REY 7 WEBB CLOSE.

I wish to object to the planning of 7 Webb Close
Pagham

P/107/61/PL.

Planning notice P/2/19/PL

PROPOSED PLANS

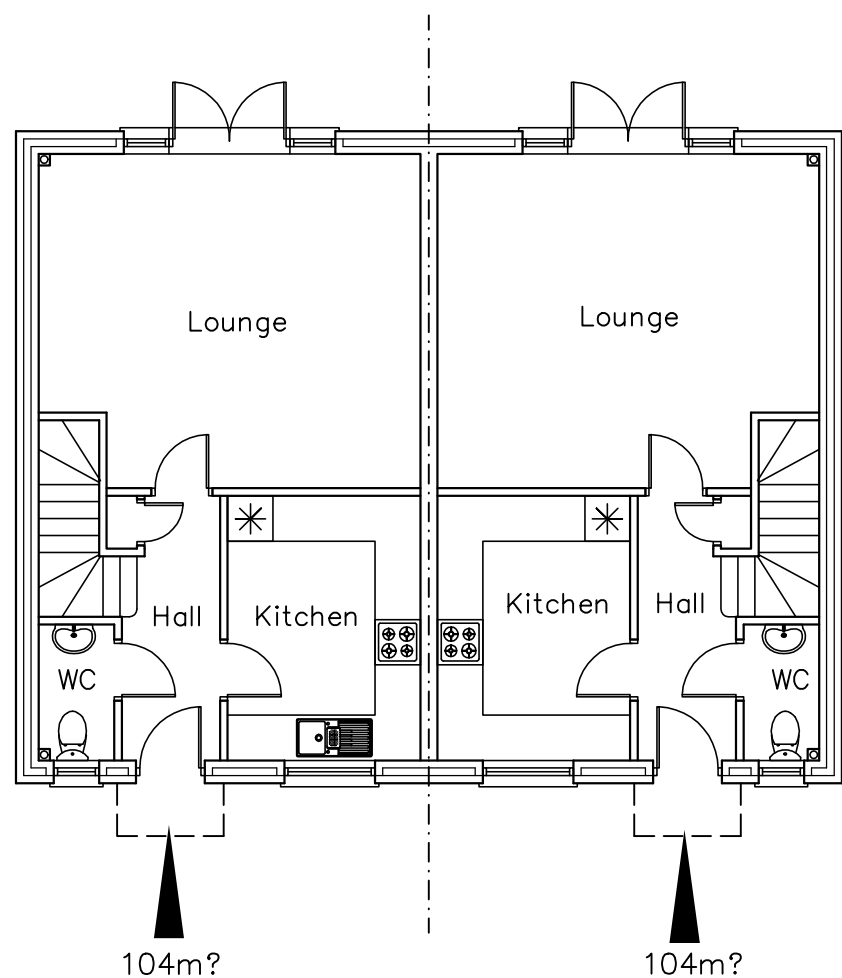
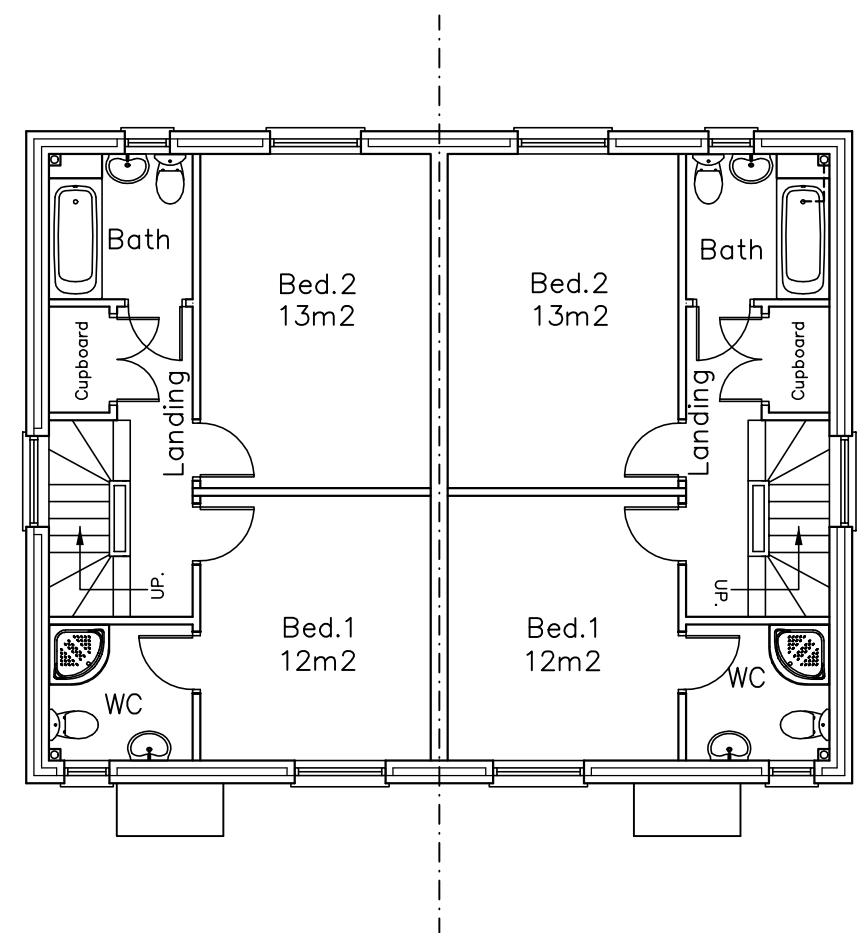
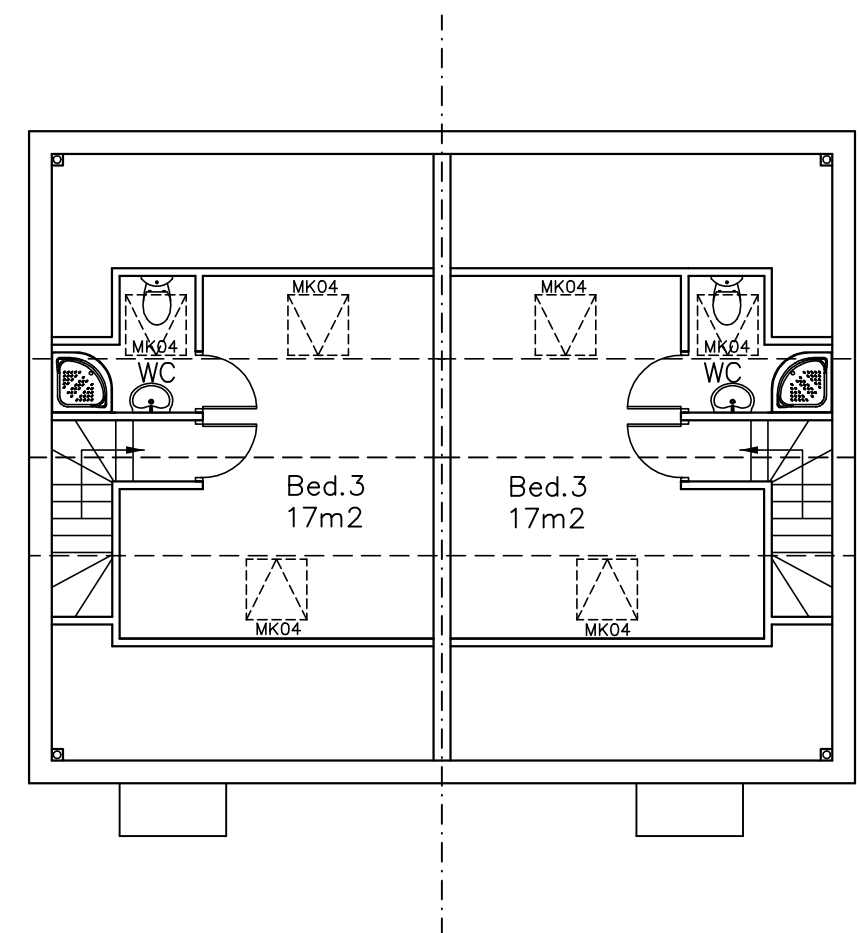
If permission is granted there could be 6
houses and not the original 4 this will have
a detrimental effect on Parkmead in
Mulberry Court, more cars will cause congestion
no large vehicles can gain access - DustCarts
fire engines ect.

PROPOSED ELEVATIONS

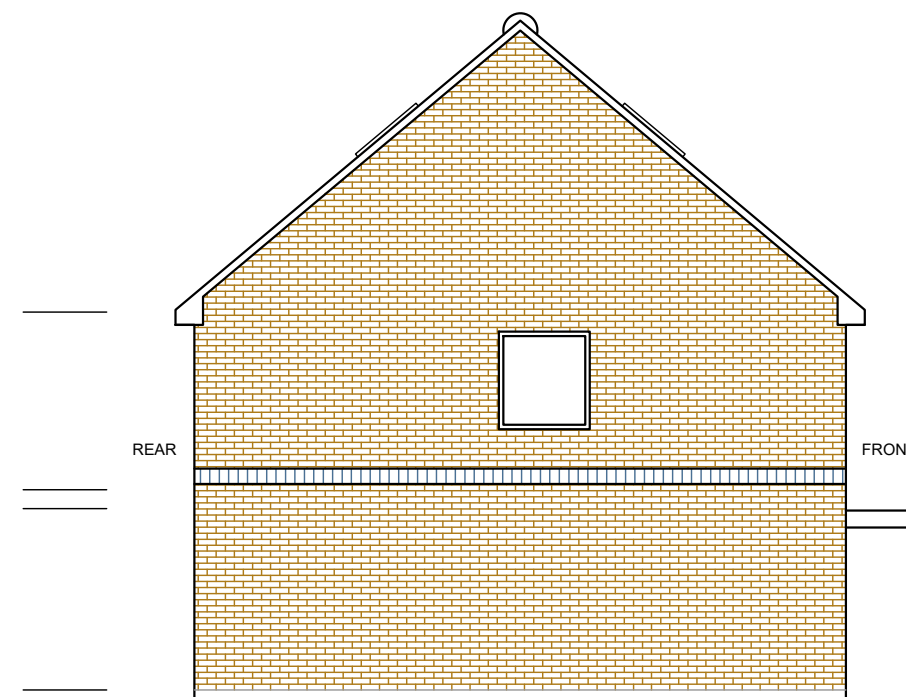
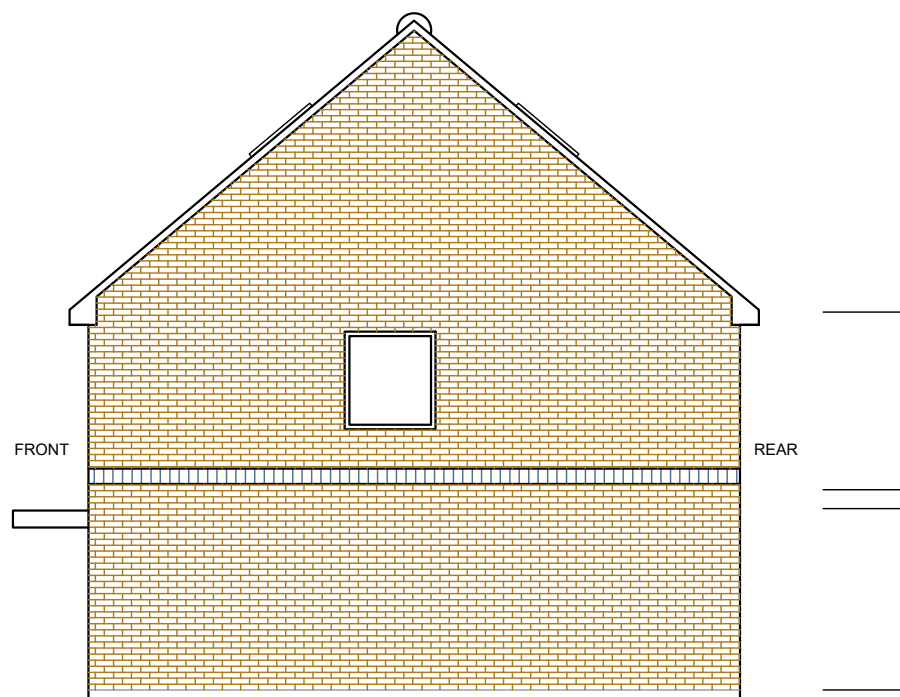
9.9.2016 - Planning approved for 2+2 Bedroom semi detached houses with 2 parking spaces on site for each house. The original roof elevations plans do not show the provision of Velux windows in the roof space.

I am concerned that my privacy will be invaded
the new houses will have direct view into my
two back bedrooms.
